# Comments for Planning Application 20/02145/HOU

Application Number: 20/02145/HOU

Address: Windrush Baring Road Cowes Isle Of Wight PO31 8DS

Proposal: Proposed single storey front facing extension; two storey side extension; rear-facing terrace decking at first floor level; alterations to include cladding to all elevations

Proposed Partial Site Plan

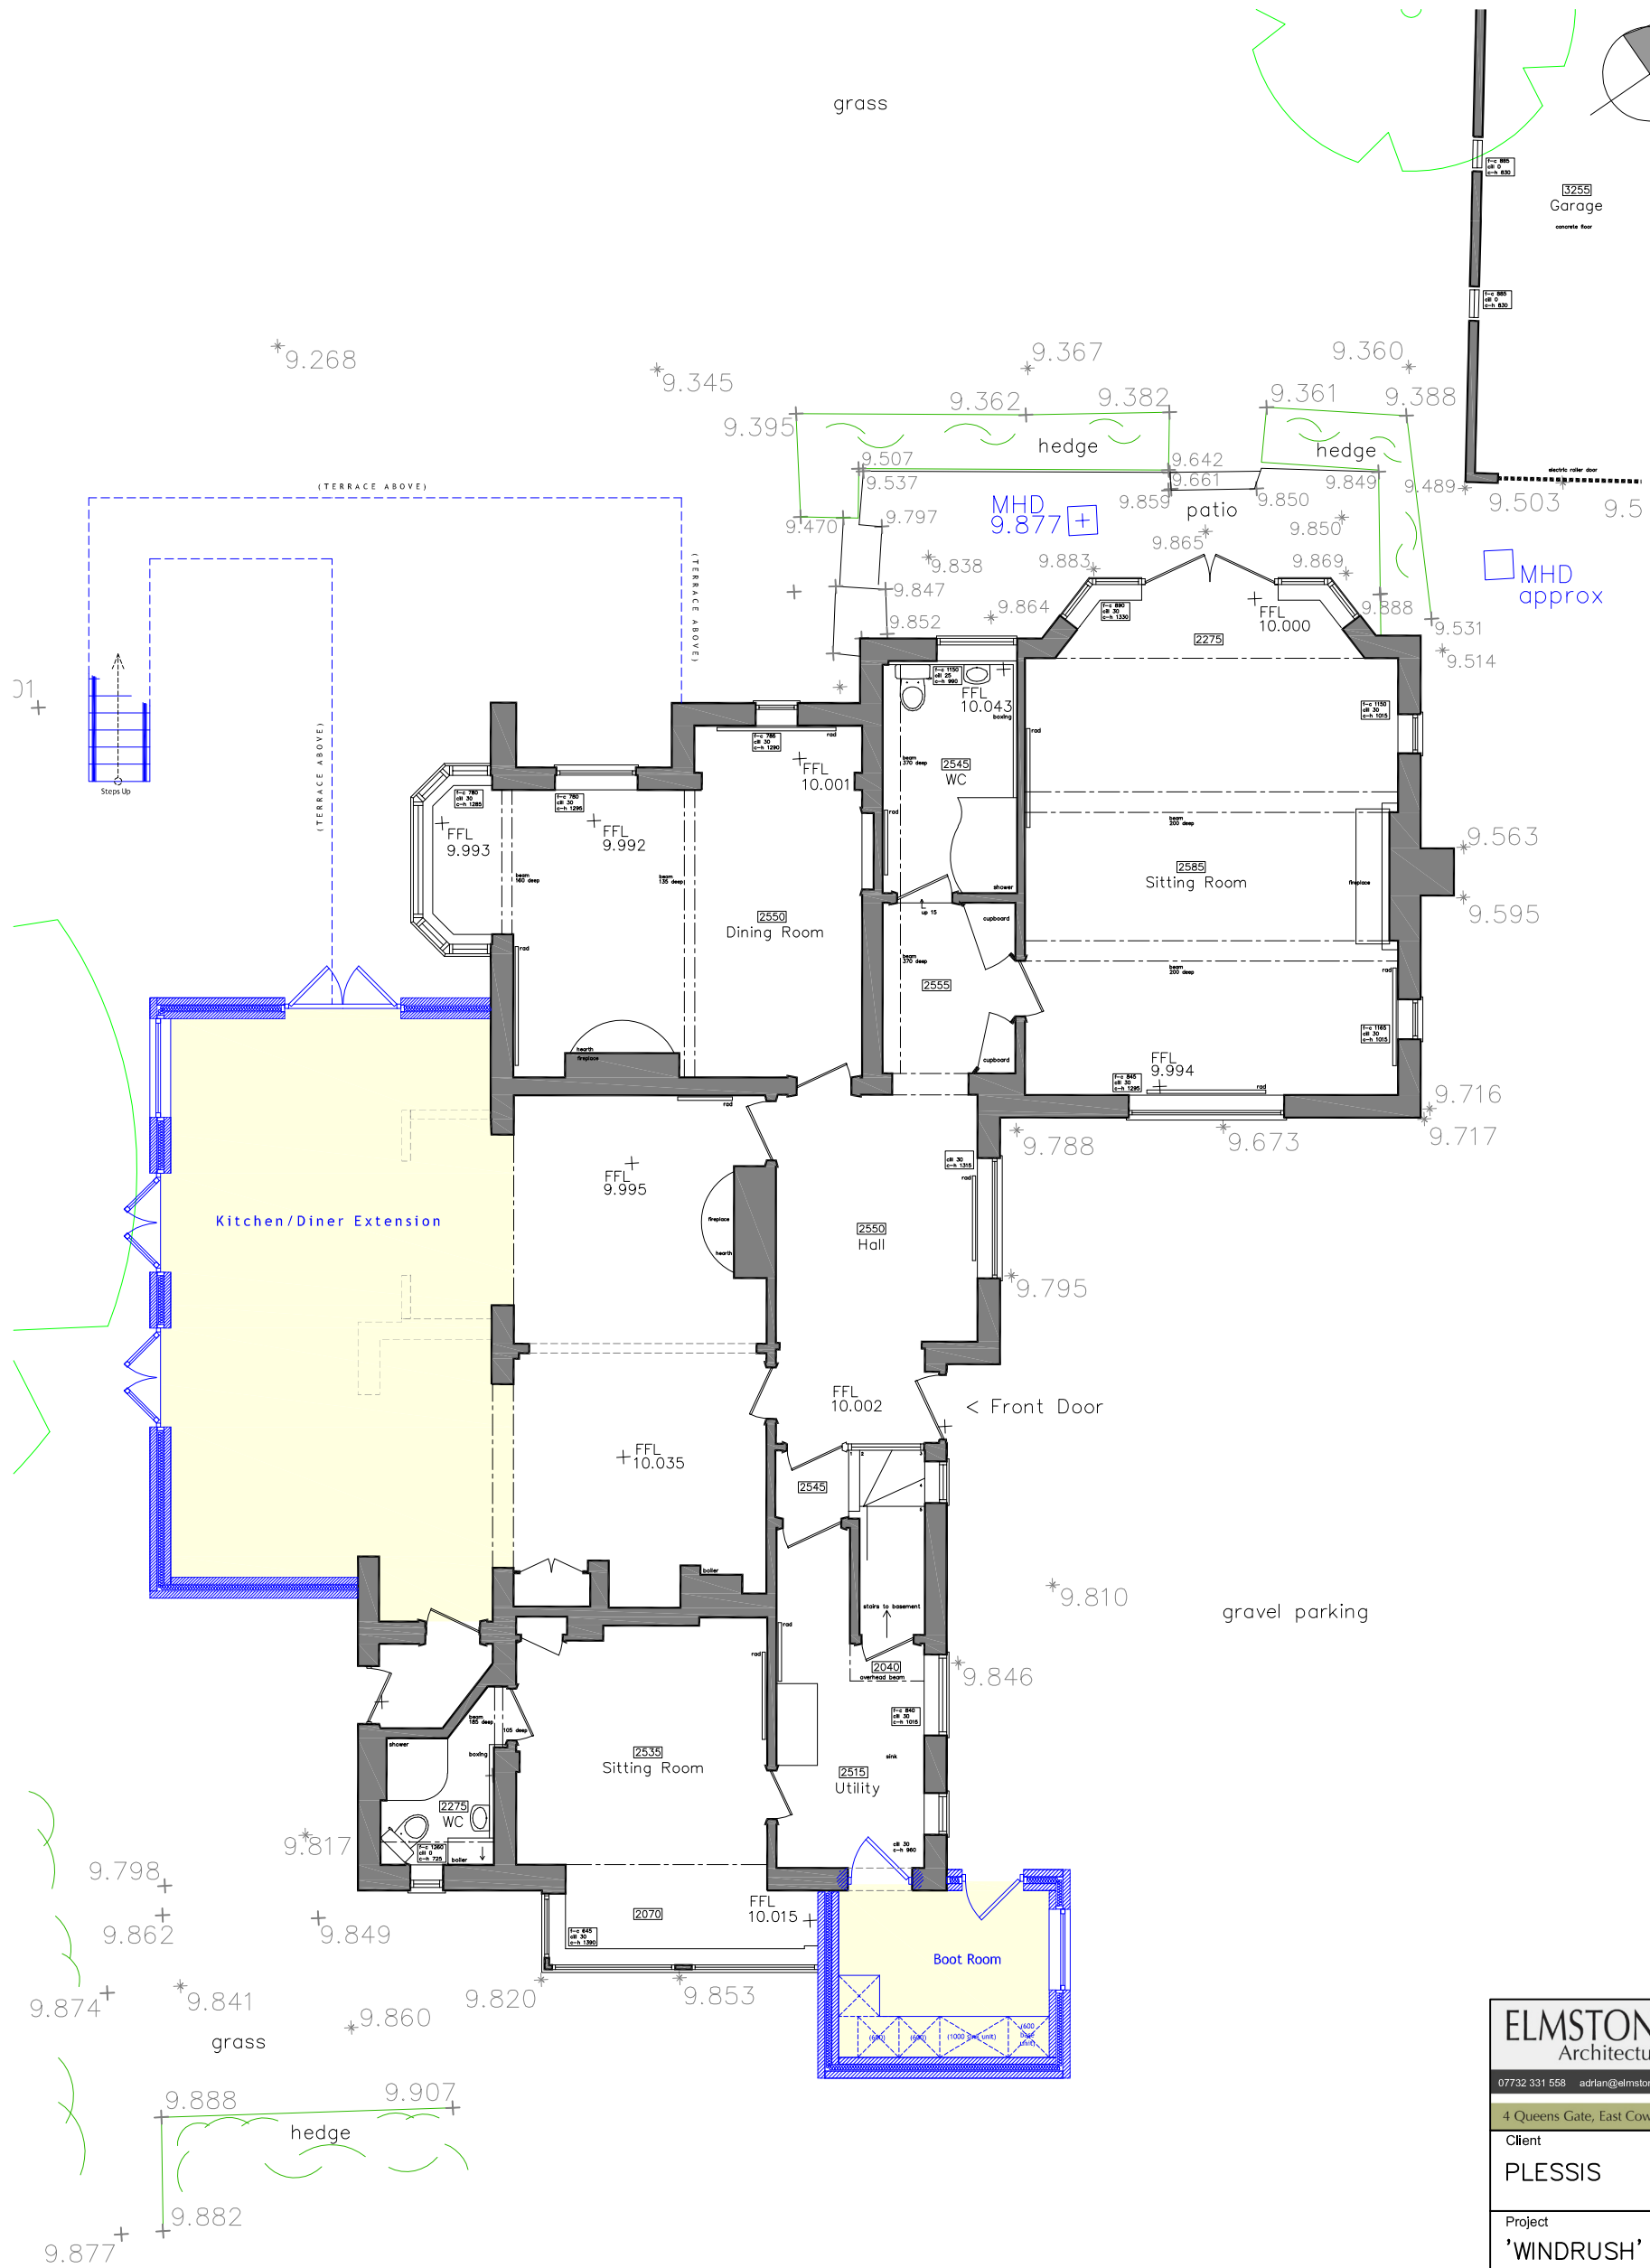
Comment: While Cowes Town Council has no objection to this application, we do, however, have a concern regarding the planned position of the garage.

This functional building has no architectural merit and being sited close to the highway will have a negative impact on the street scene. We feel it would be better sited beside or closer to the main building.
